Department for
Energy Security
& Net Zero

Date: 14 August 2023

Application by Awel y Môr Offshore Wind Farm Limited (“the Applicant”) for an Order granting Development Consent for the proposed Awel y Môr Offshore Wind Farm (“the Proposed Development”)

Request for Information

Sheet No: 4 of 5
 SCALE: 1:2,500 PLOT SIZE: A1 DATUM: OSGB 1936 PROJECTION: BNG

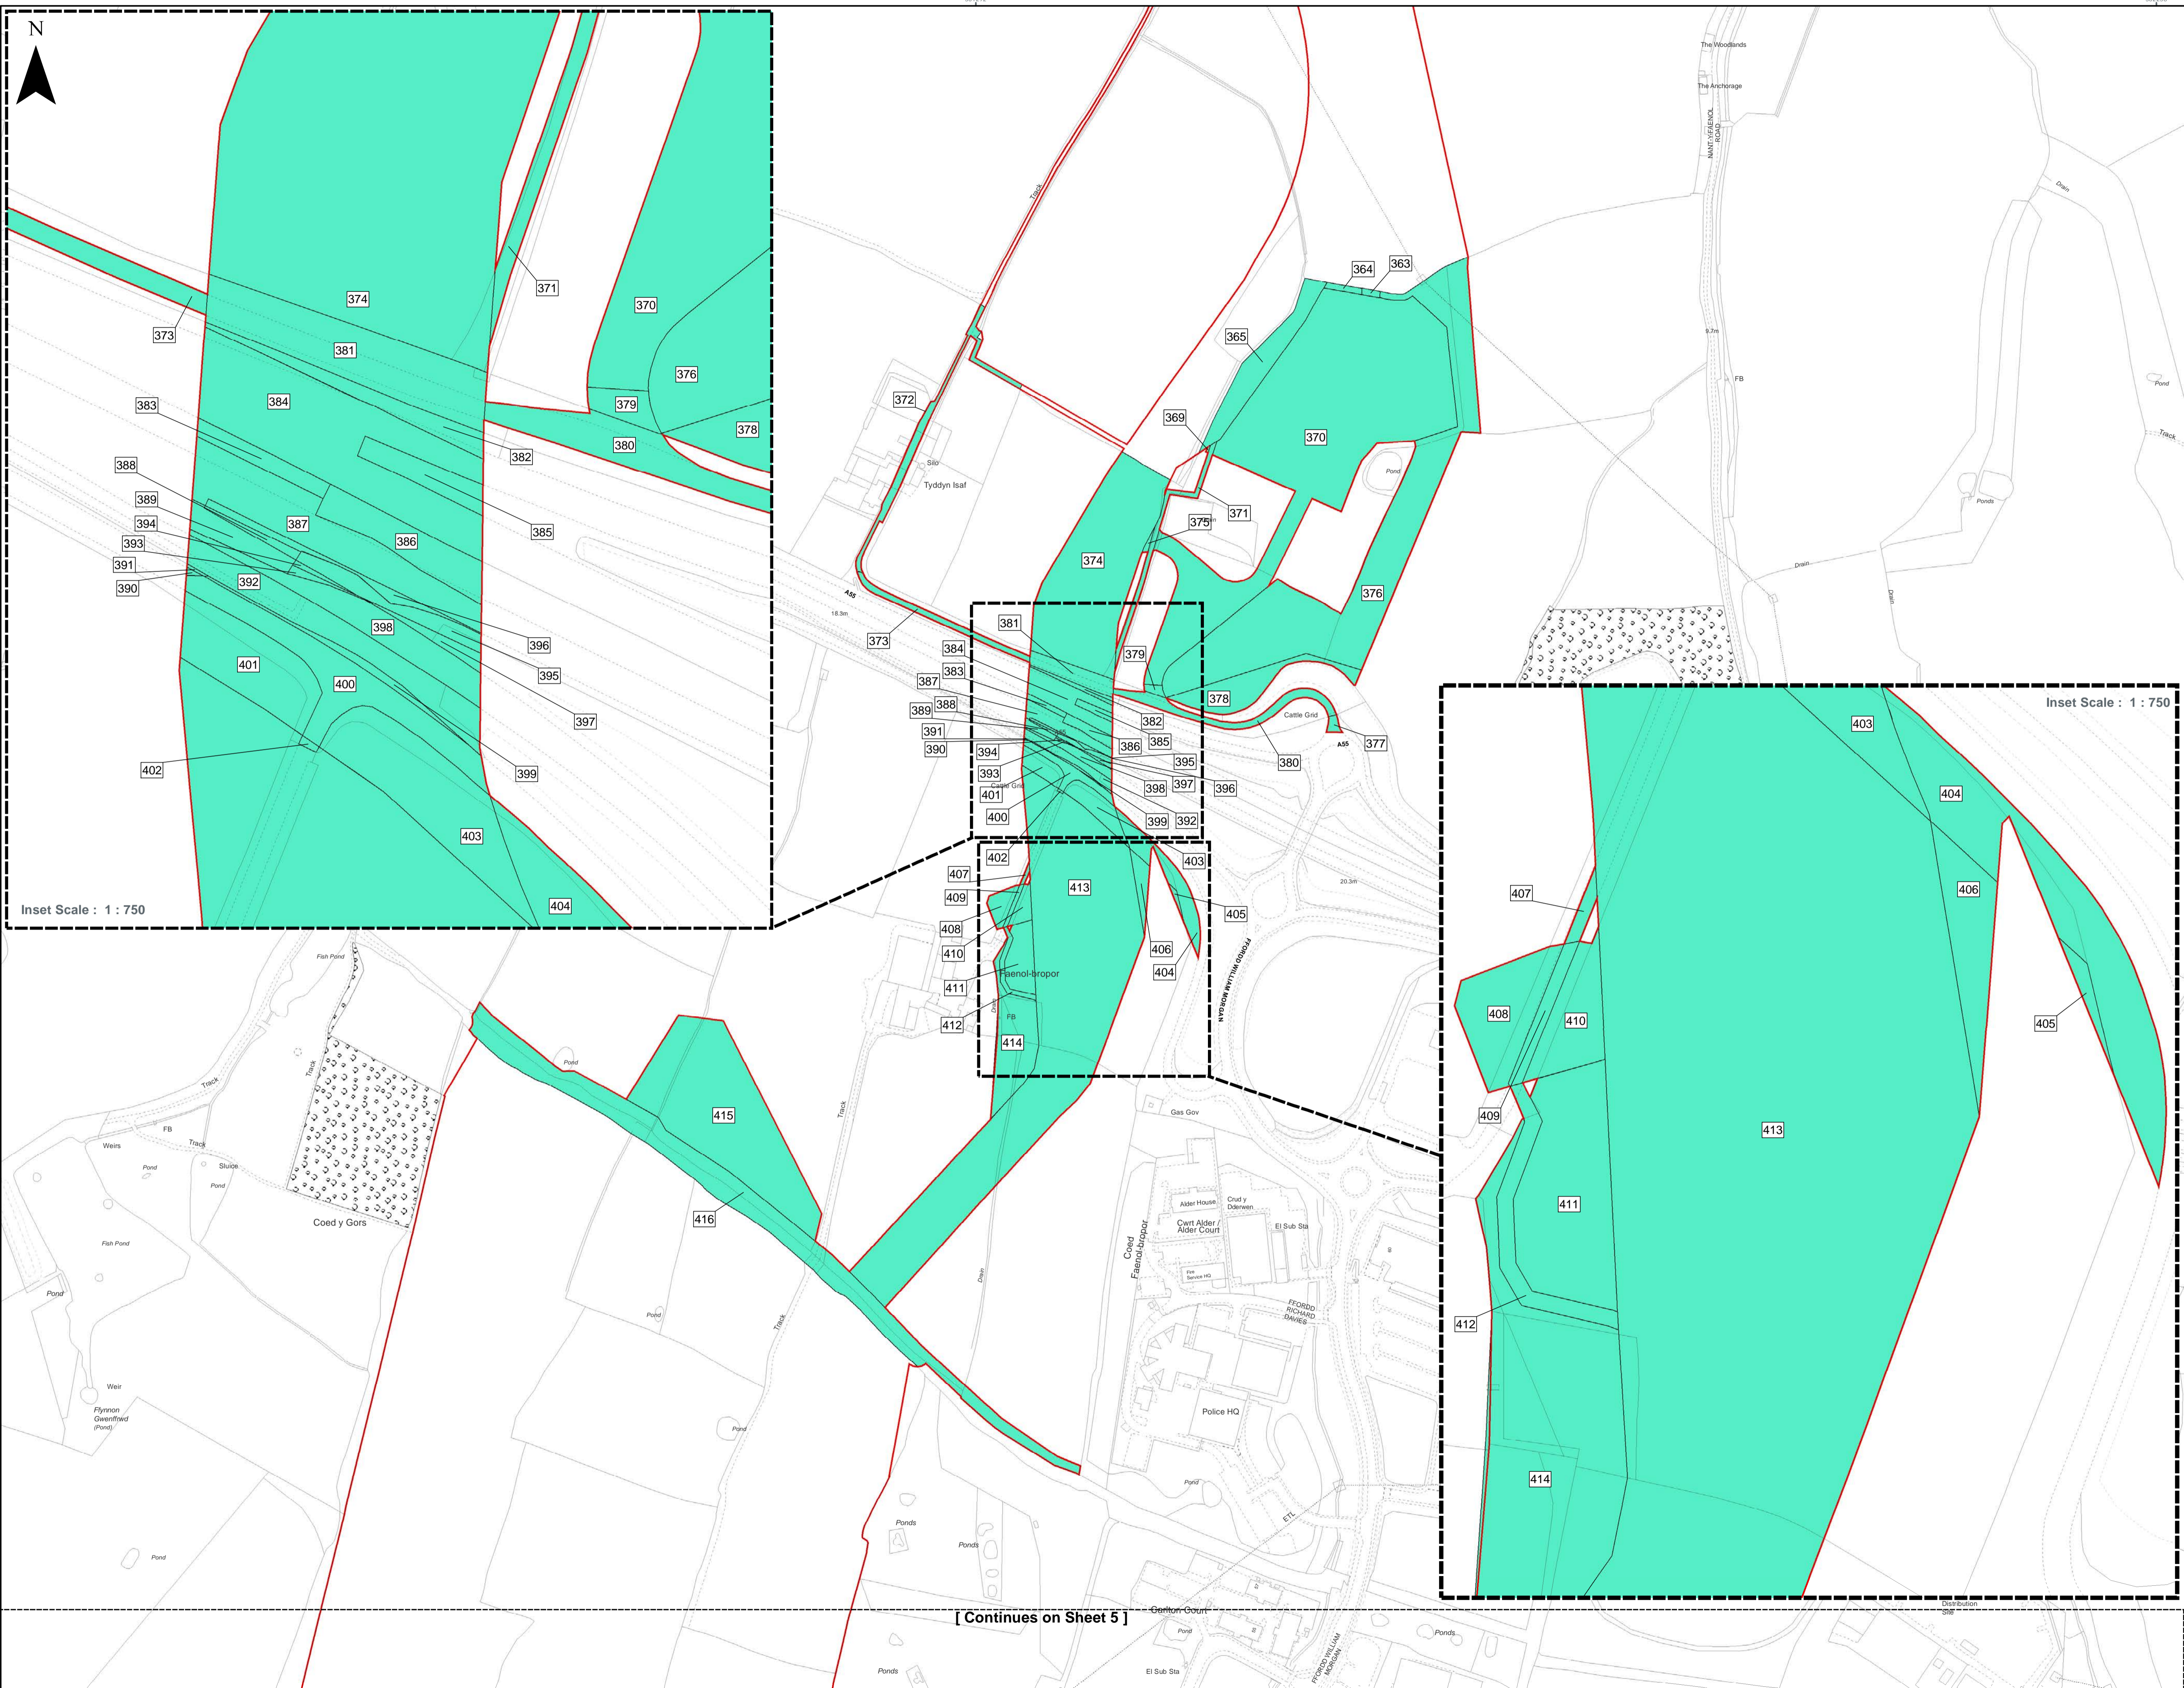
5. The Secretary of State notes that in the Crown Land Plan, the legends on Sheets 4 and 5 name The Crown Estate as having an interest in the land, whereas the Book of Reference names the Welsh Government. The **Applicant** is requested to clarify this inconsistency.
